CITY OF ALBUQUERQUE

December 7, 2015

RE: Valle Vista at the Trails, Unit 2 (File: C09D009)
Grading and Drainage Plan,
Engineer's Stamp Date 6-23-2014
Engineer's Certification Date : 10-22-15

VALLE VISTA UNITS 1, 2 & 3
GRADING AND DRAINAGE PLAN

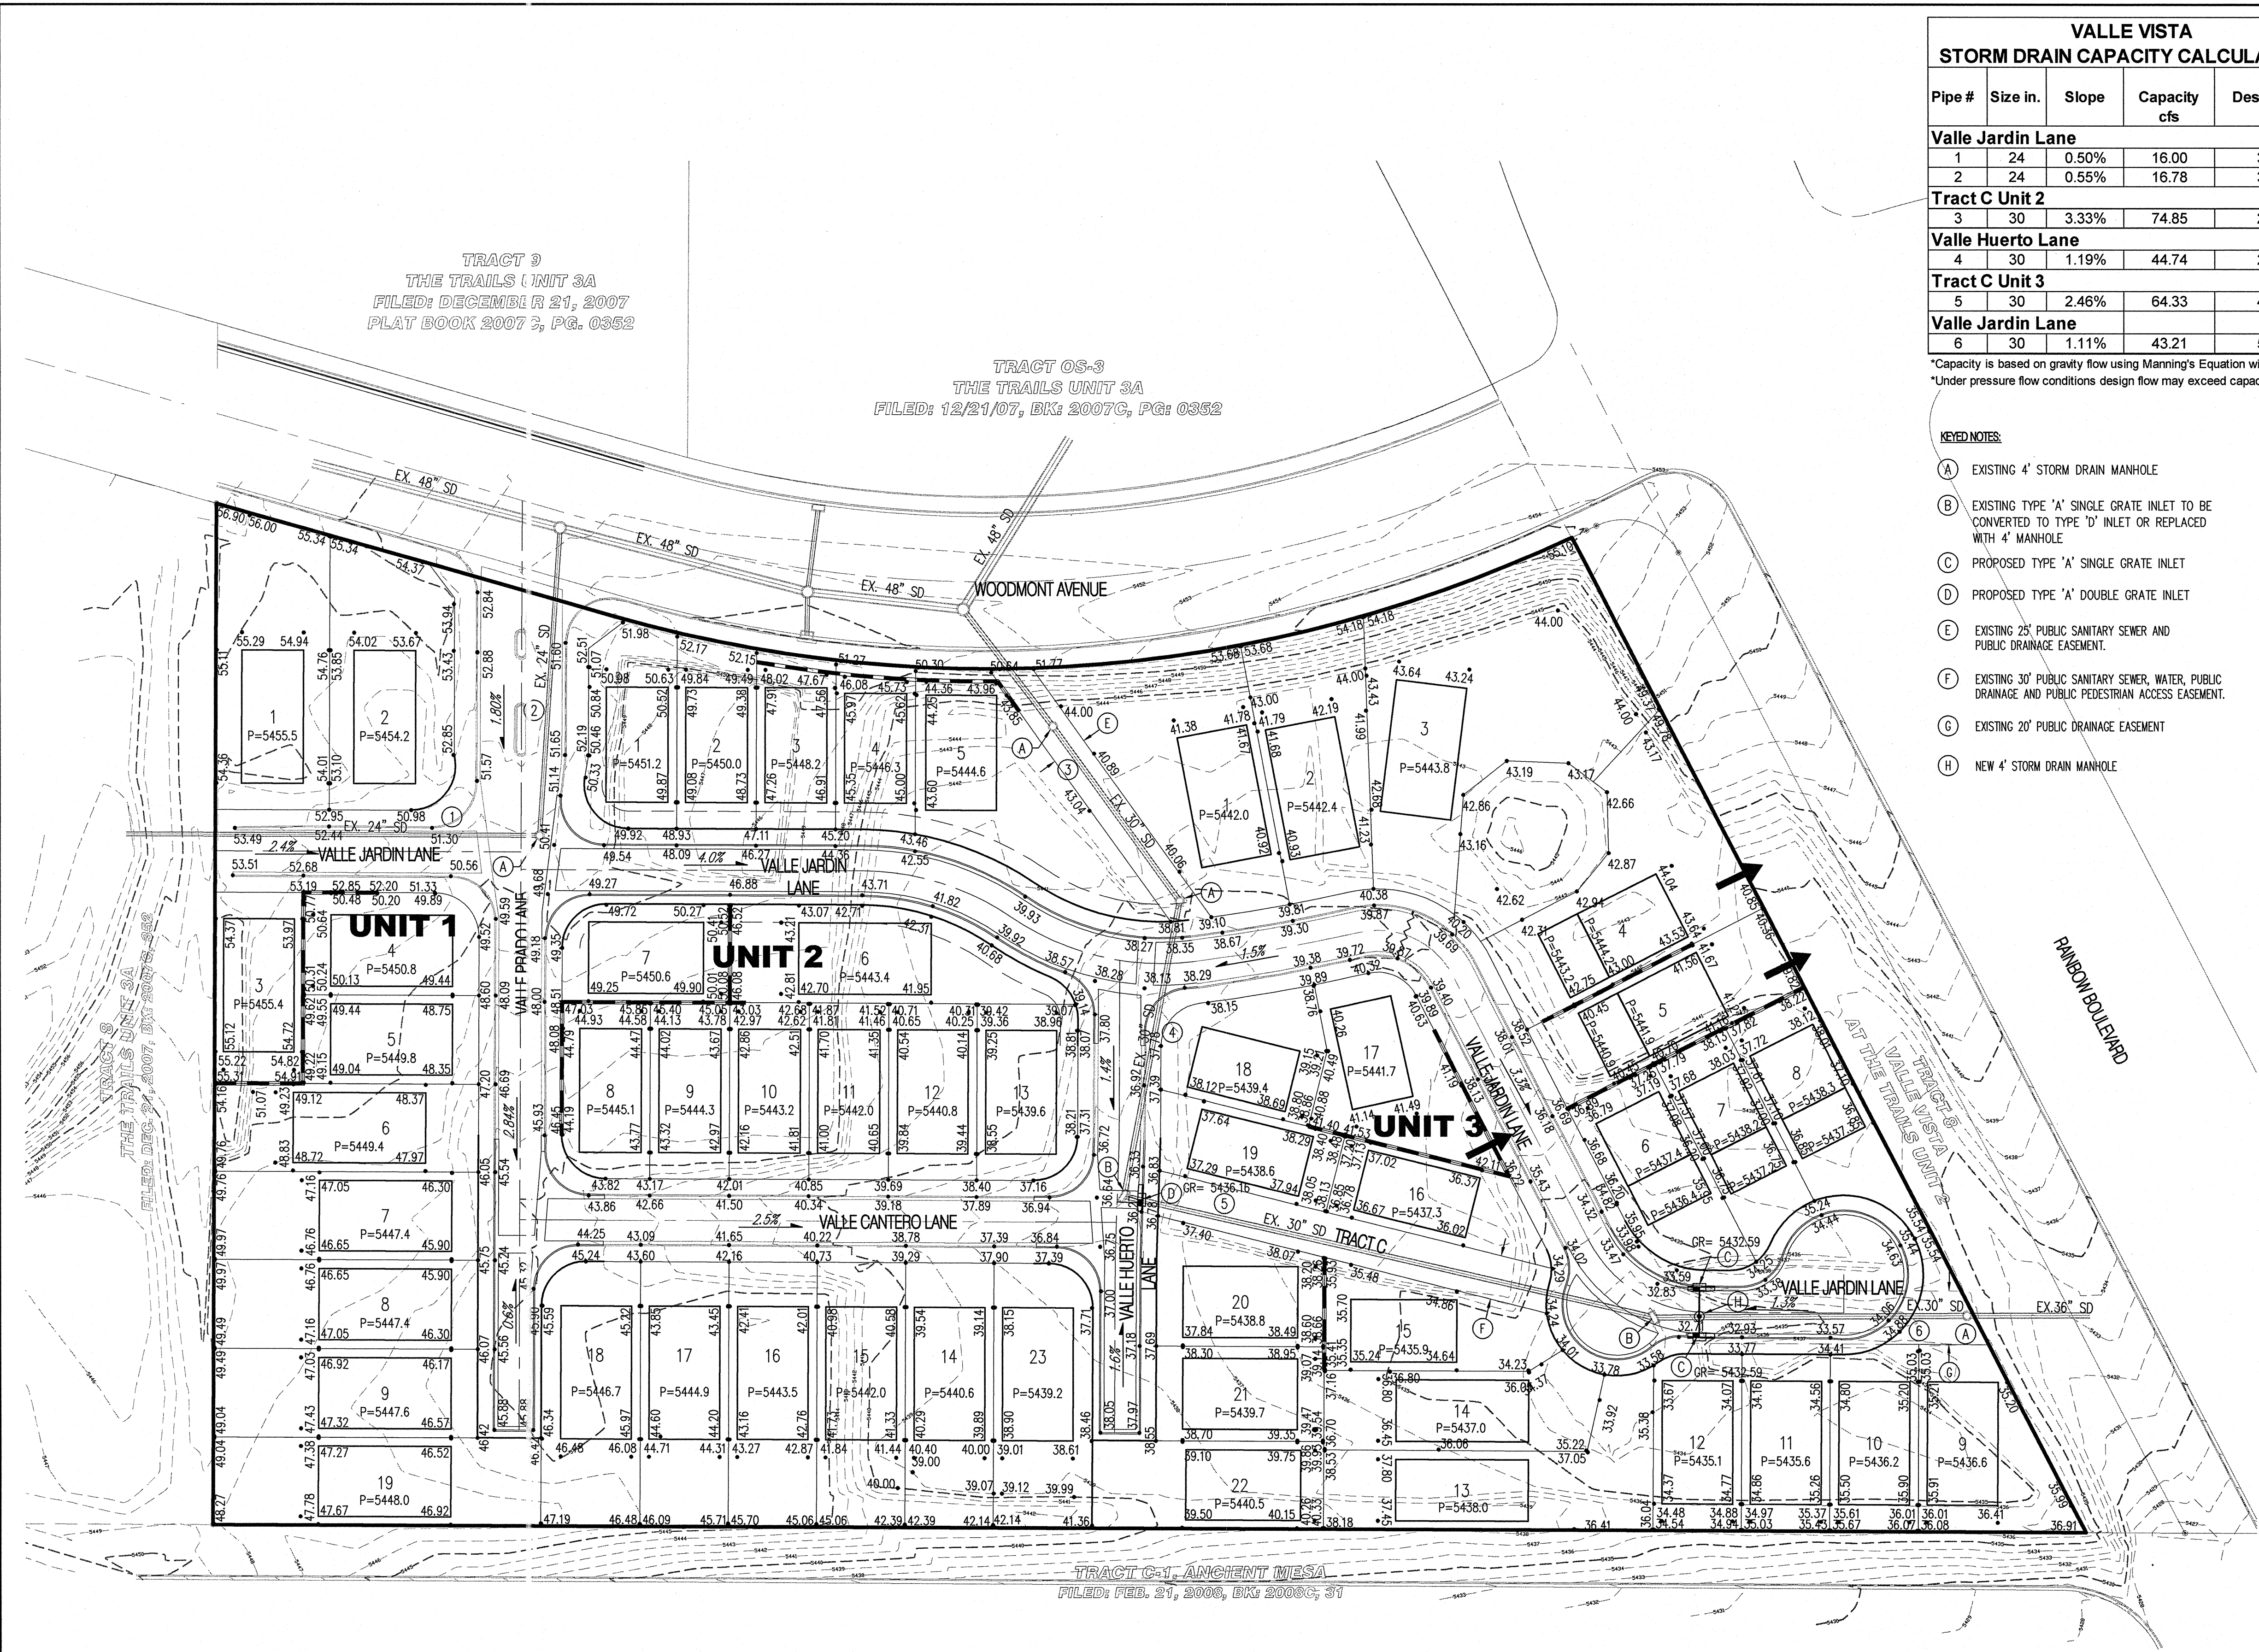
2. The retaining wall at the rear of Lot 5 appears to have collapsed.
3. Manhole in SD Tract east of Lot 5 needs to be adjusted to grade.
4. Lot 3 rear retaining wall is intended to be a garden wall retaining 2' to be built by the homebuilder. However, what mechanism is in place for the City to ensure that such a wall is built? If no such mechanism is in place, this wall should be constructed prior to Release of Financial Guarantee. Furthermore, should the garden wall not be built, the existing wall beyond is susceptible to overturning since the supporting soil is not in place.

5. The split between Lots 7 and 8 is over 2', and needs a retaining wall as per the plan.
6. The split between Lot 6 and 7 is over 4' and needs a retaining wall as per the plan.
